Application No: WA/63/21/PL
Site Address: Land East of Tye Lane Walberton BN18 0LU
Description of works: Proposed alternative vehicular accesses off Tye Lane and emergency access off Avisford Park Road, along with minor highway works following WA/95/18/RES (resubmission following WA/93/20/PL). This site is CIL Zone 2 (Zero Rated) as other development.

Thank you for your internet representation made on 4th August 2021 which has been recorded as an objection with the comments as follows:

Drawing Title:
PROPOSED ALTERNATIVE ACCESS

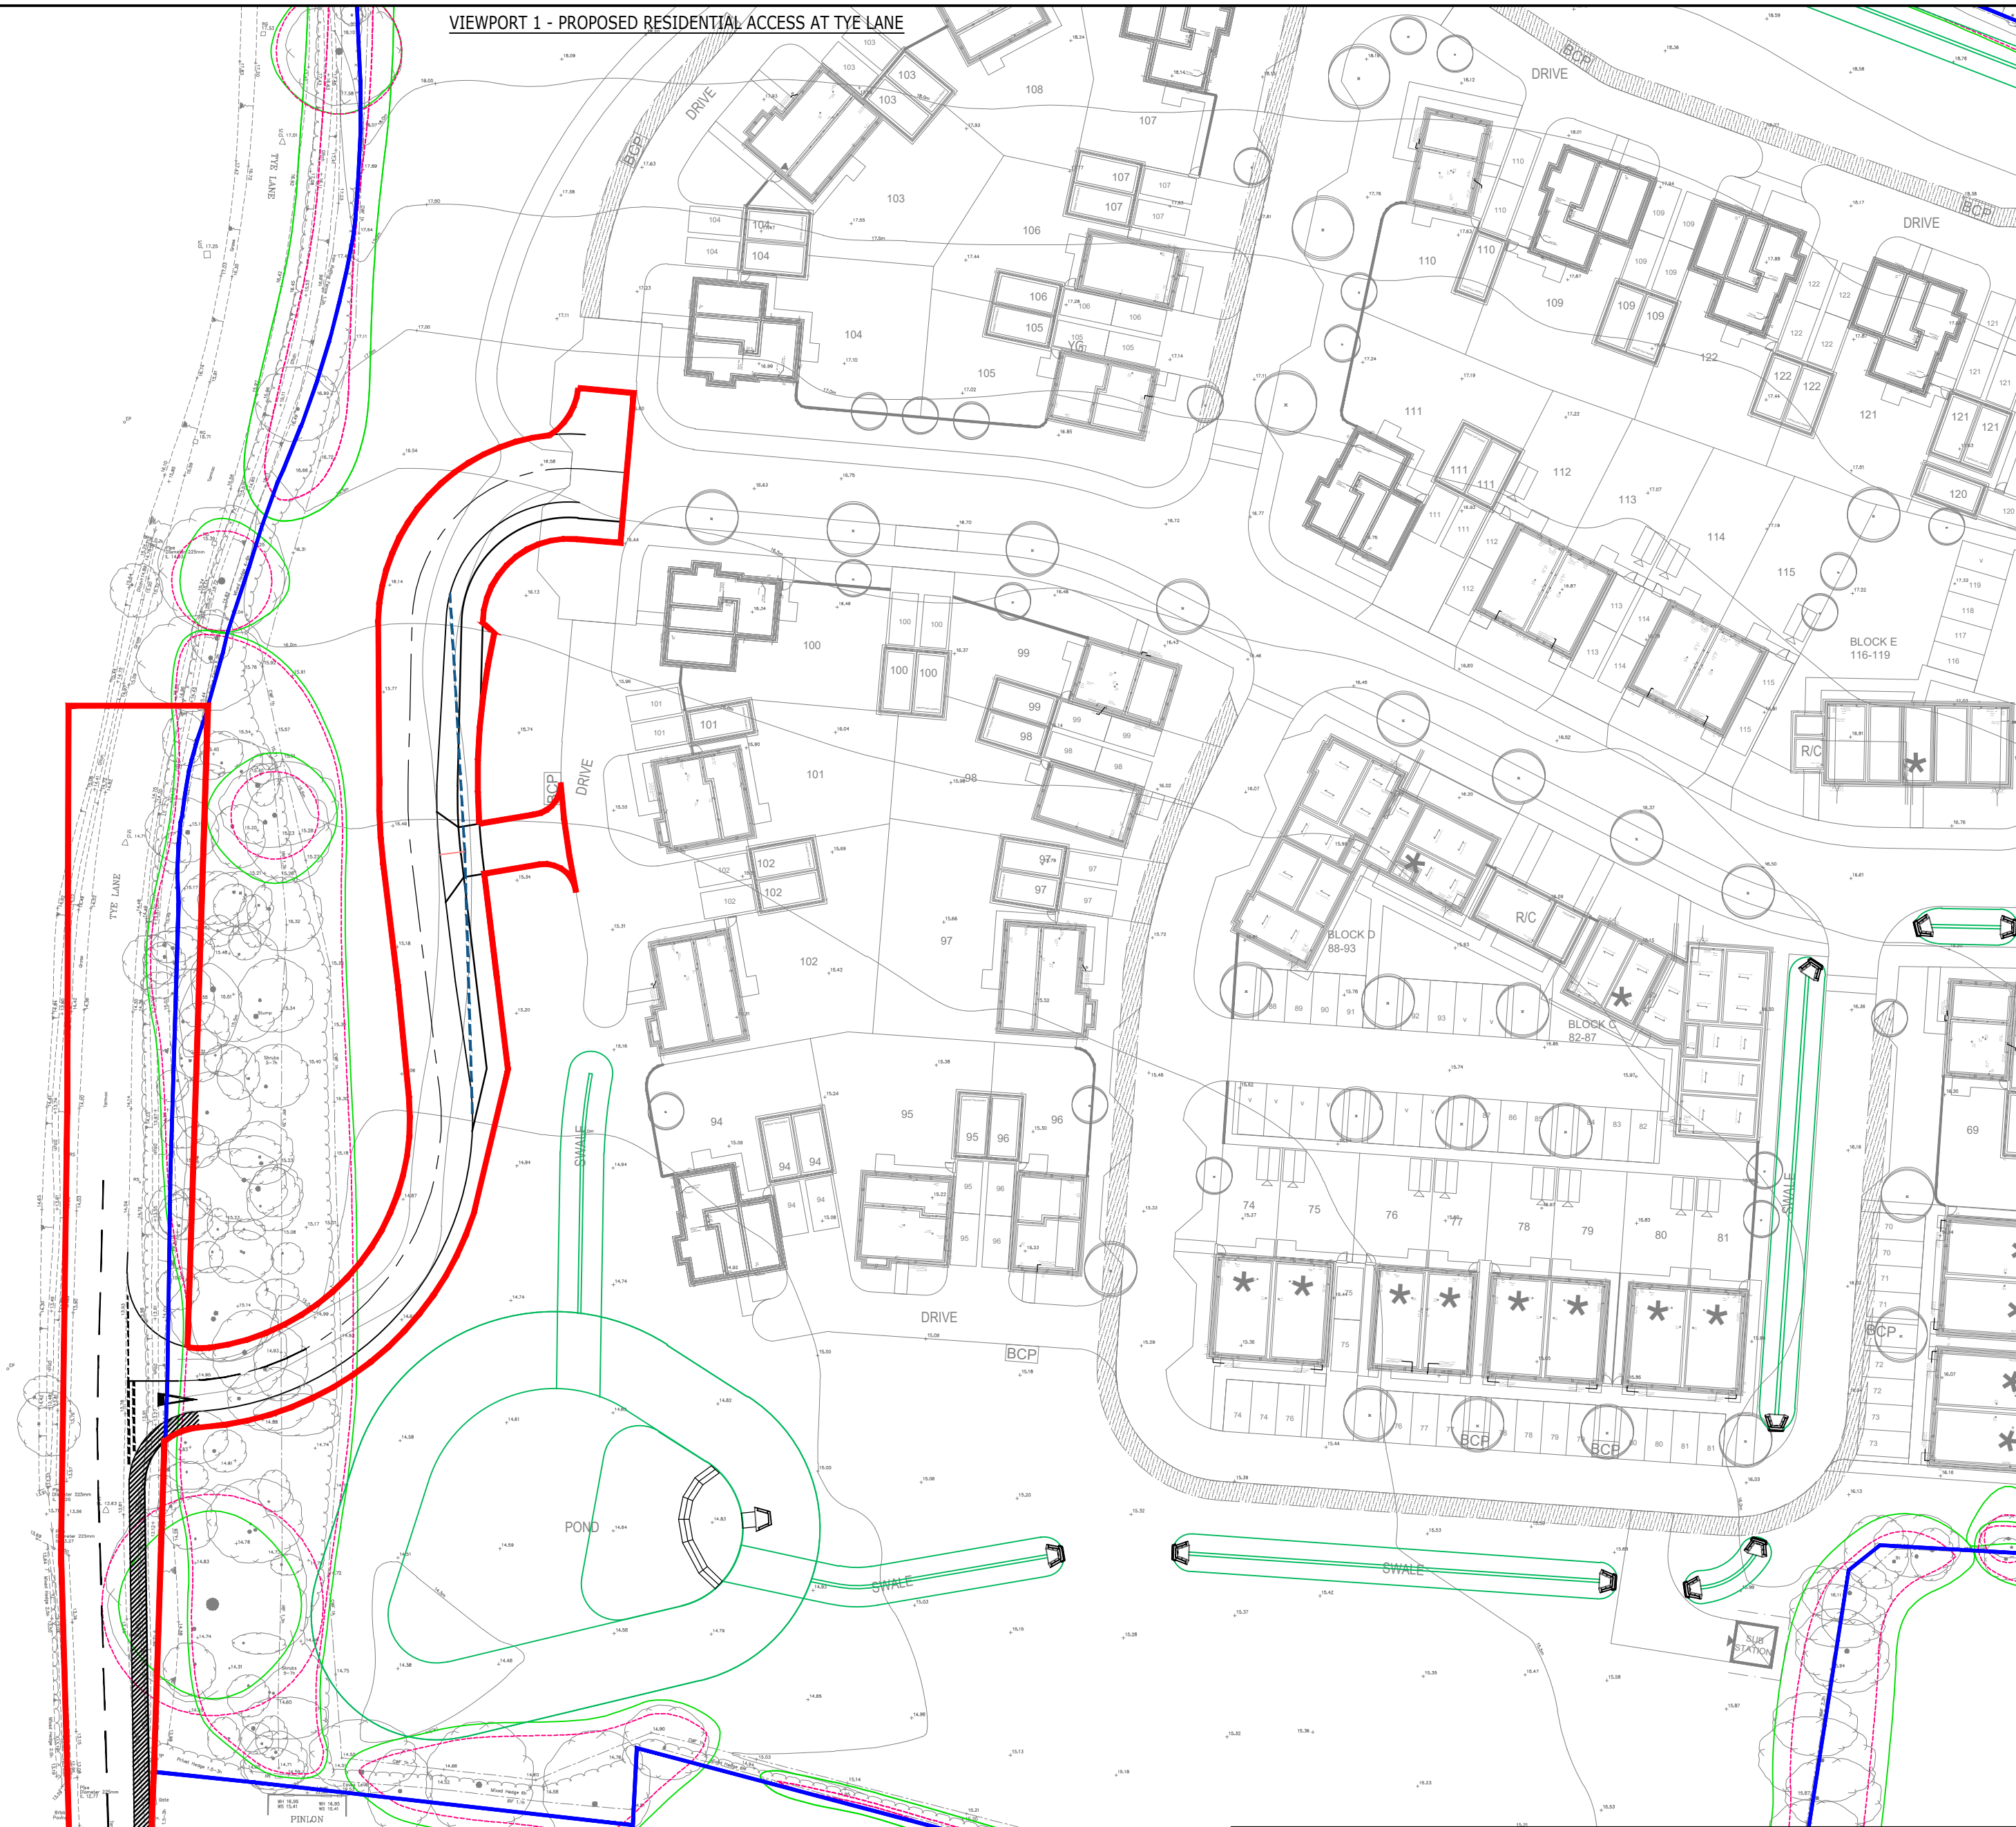
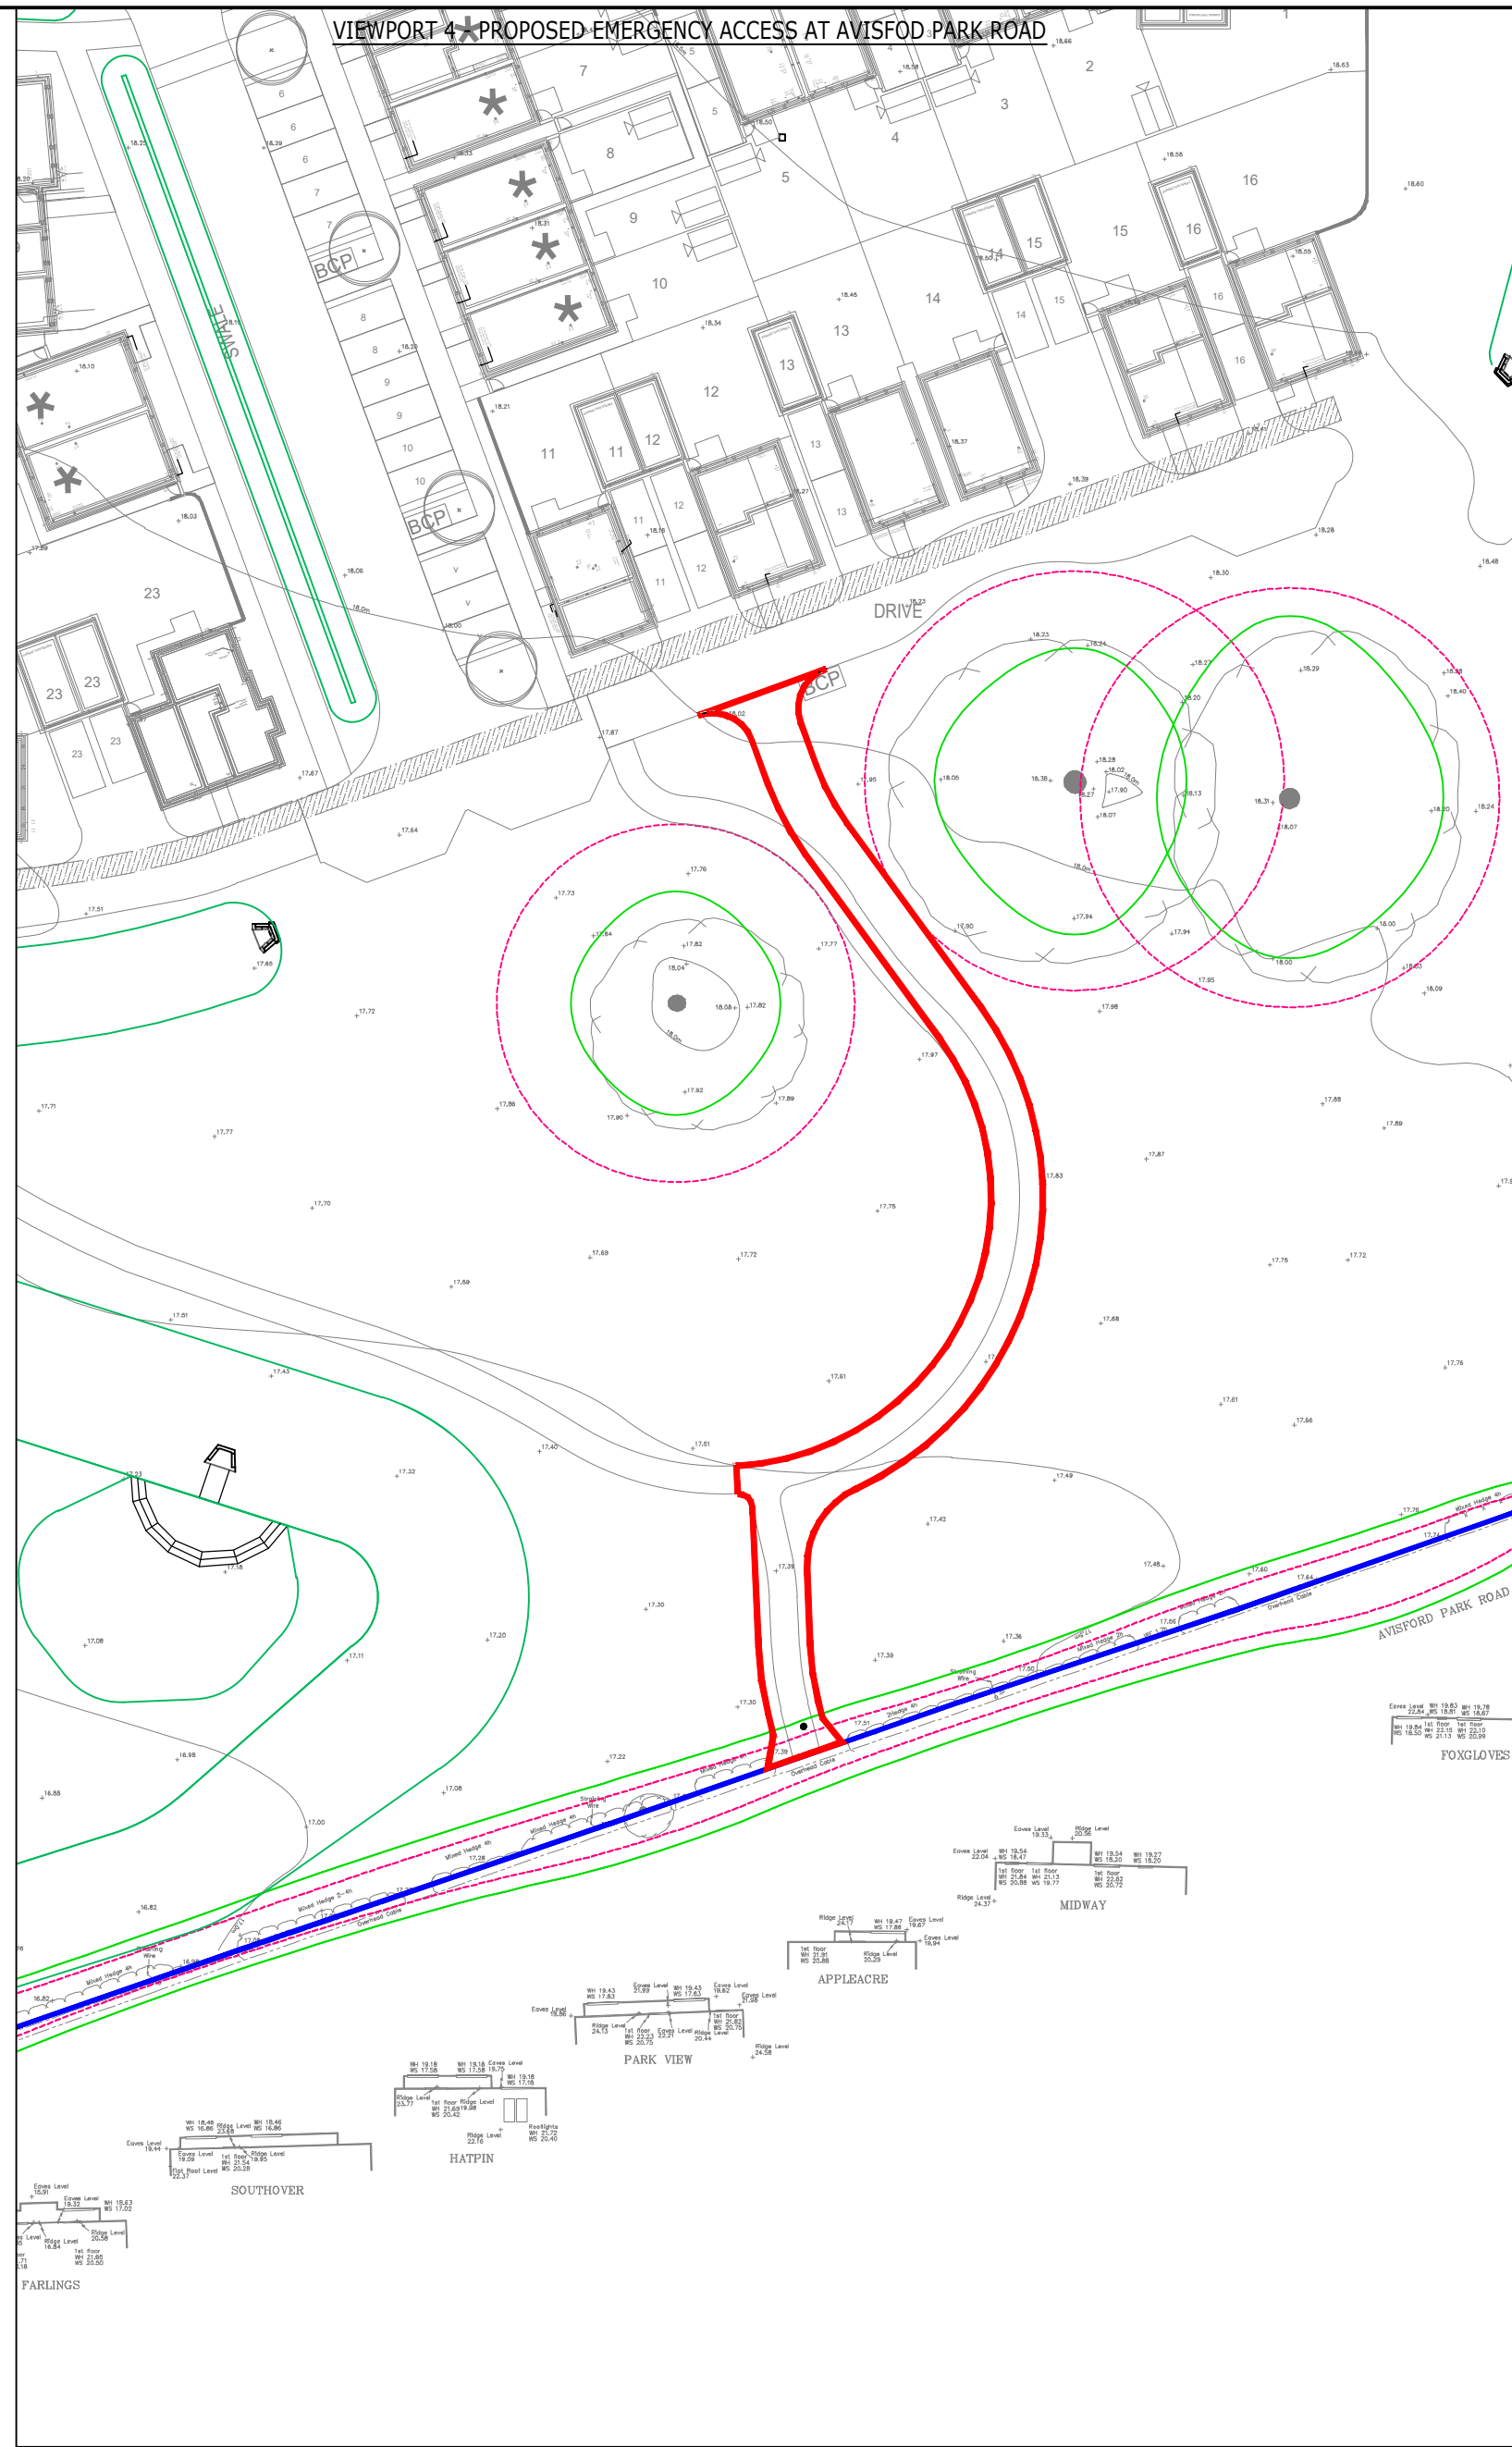
Tye Lane is significantly narrower than Yapton Lane for vehicle movements. The new application reduces Tye Lane to a minimum of 4.8m rather than 5.0m for approximately 25m which would mean that a HGV and a car could no longer pass at this point. 2 vans (2.4m wide) would be able to pass with zero clearance between vans and kerb and the vans themselves, encouraging vehicles to mount the pavement. 5 of the 6 houses at The Street end of Tye Lane have land ownership up to the current highway boundary. 2 of the houses do not have driveways or garages and cars are legally parked on the road further reducing safety if traffic along this road is to be increased. Parking on The Street can also impact on the visibility for vehicles pulling out into The Street at this junction.

The proposed cycle route from AG leads down this narrowed route which will pose increased risks to cyclist from traffic trying to pass them. The reduced road width to accommodate the new access point poses increased dangers to pedestrians, cyclists, horse riders and vehicular traffic.
